**Drainage Memo  
Fountain Valley School**

**El Paso County, Colorado**

Kiowa Project No. 19006

April 1, 2019

FIGURE 2

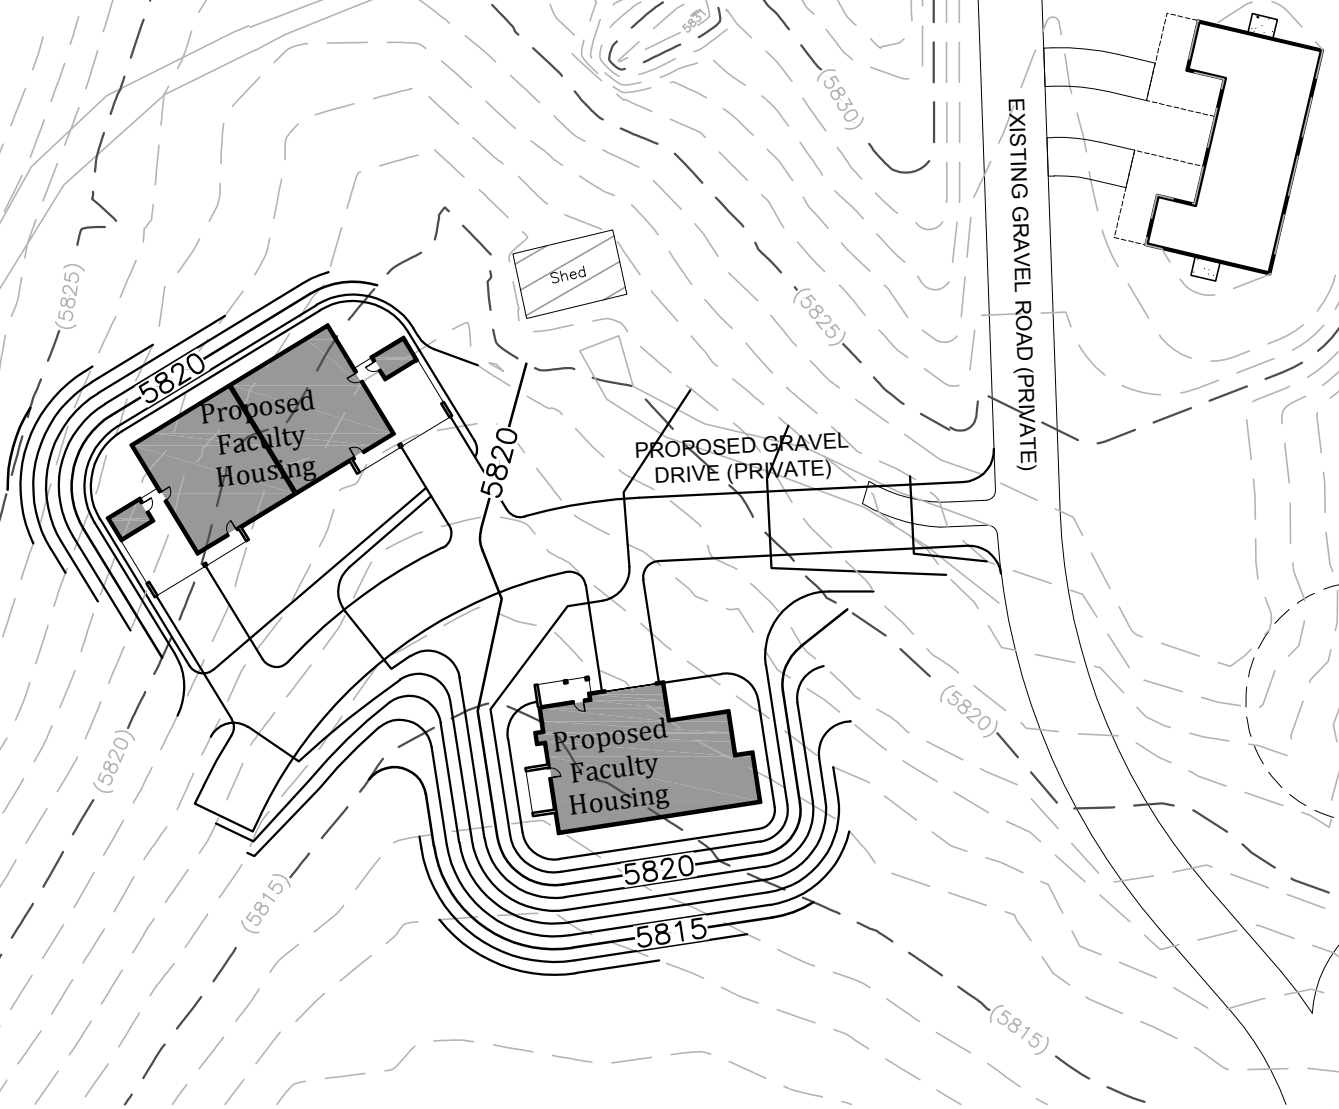
Please provide contour and slope labels at the proposed grading.

What is this? Please identify.
